**RESPONSE TO KEY ISSUES LETTER
V BY CROWN | 45 MACQUARIE STREET, PARRAMATTA**

We write in response to the Department of Planning & Environment's (DP&E) letter of 10 December 2014, relating to 45-47 Macquarie Street and 134-140 Marsden Street, Parramatta (V by Crown) and MP09_0167 MOD4.

3102 East Elevation

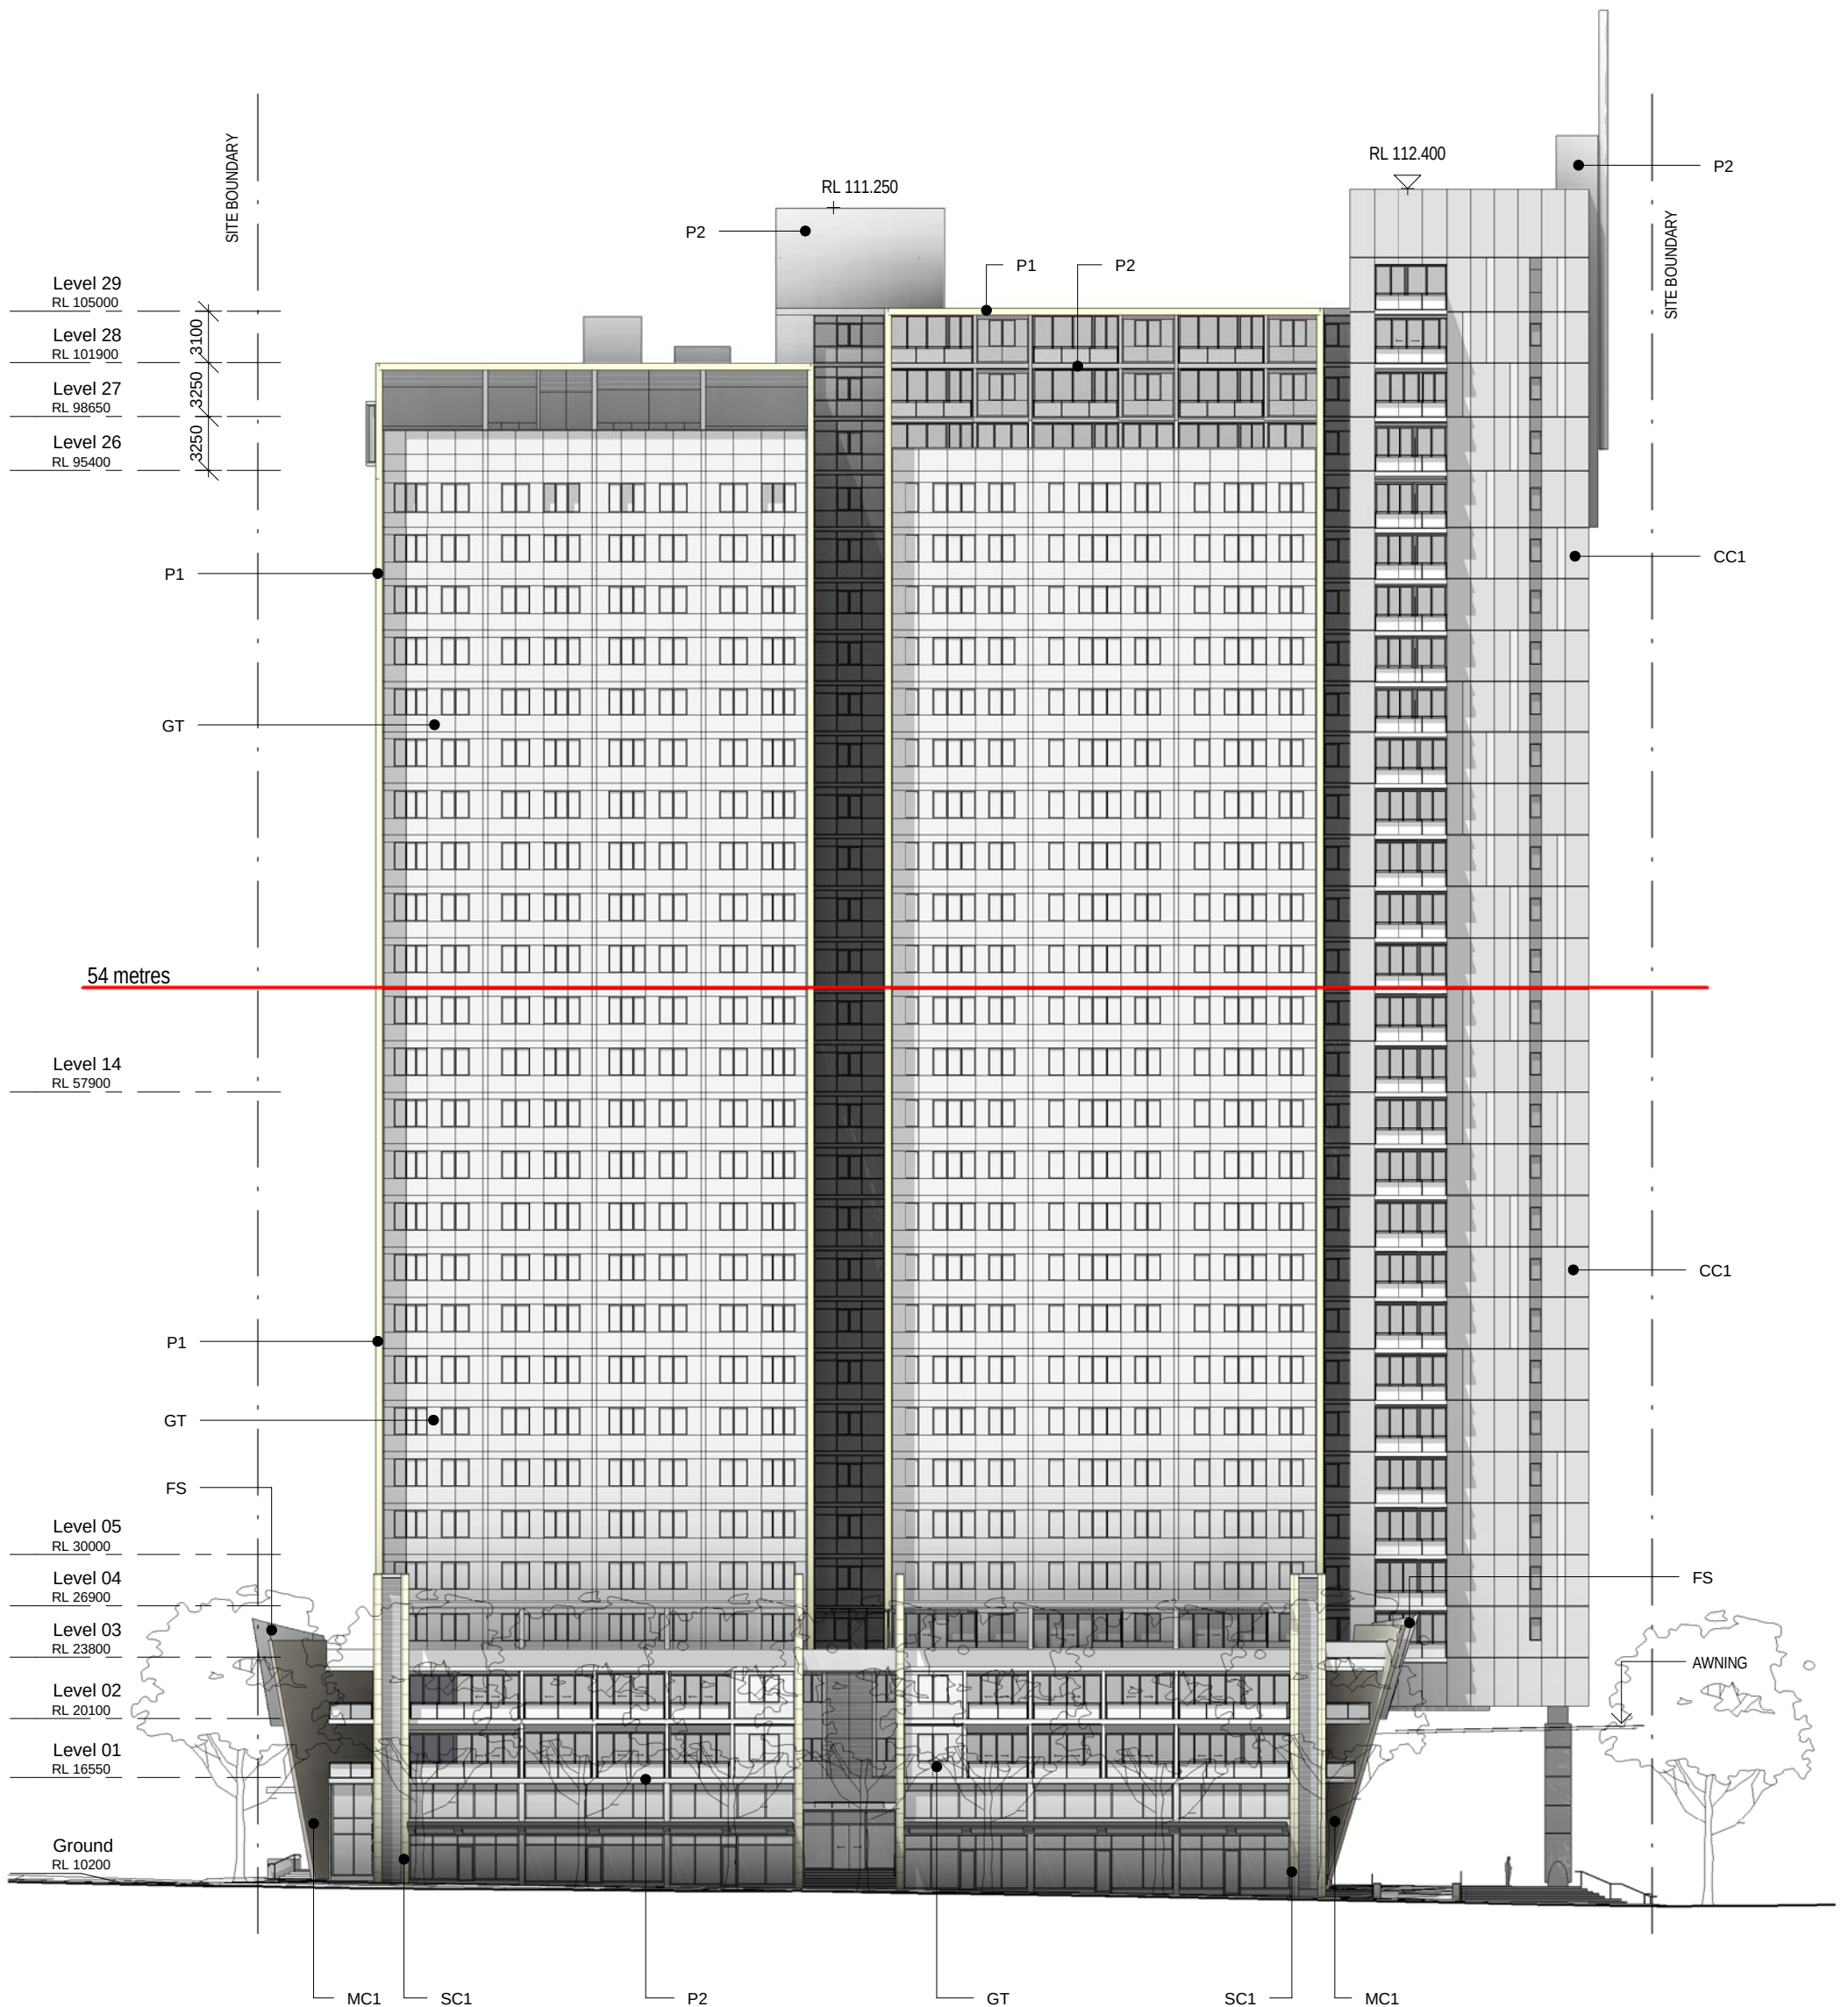
- a) **further consideration of the architectural approach to the Hunter St façade (up to 54m).** *The division of the façade is an appropriate method of articulation and visually emphasises verticality. However, the central strip, which includes a colour/material change, contrasts poorly within the context of the overall design of the development and this element is unlikely to have the same visual benefit / be read in the same way as the deep recesses on the Marsden Street elevation.*
 - *a potential alternative option could be to divide the elevation in half and provide two projecting wrap-around features which are separated by an expressed gap (eg attached).*
- b) **addition visual interest to the blank flank wall (east) (above 54m).** *The colour/material change of the wall at this level is acceptable. However, the wall's unrelieved blank nature is likely to draw undue attention.*

- *a potential alternative option could be to insert a column of windows (offset from those below) into the wall.*

In our view, the wider strip better achieves the desired articulation. Further, placing the two frames close together would require additional structural support, as they would not connect to the other pre-cast concrete walls behind. As a middle ground, AJ + C have replaced all fixed glass in this strip with dark-coloured glazing. This should serve to increase contrast and emphasise the division and verticality of the façade.

AJ + C have considered the proposal to add windows to the eastern face of the south-facing frame and believe that a solid frame is more consistent with the adjacent solid frame of the south-facing Marsden Street façade. Therefore, it is proposed that this façade remain solid and unchanged.
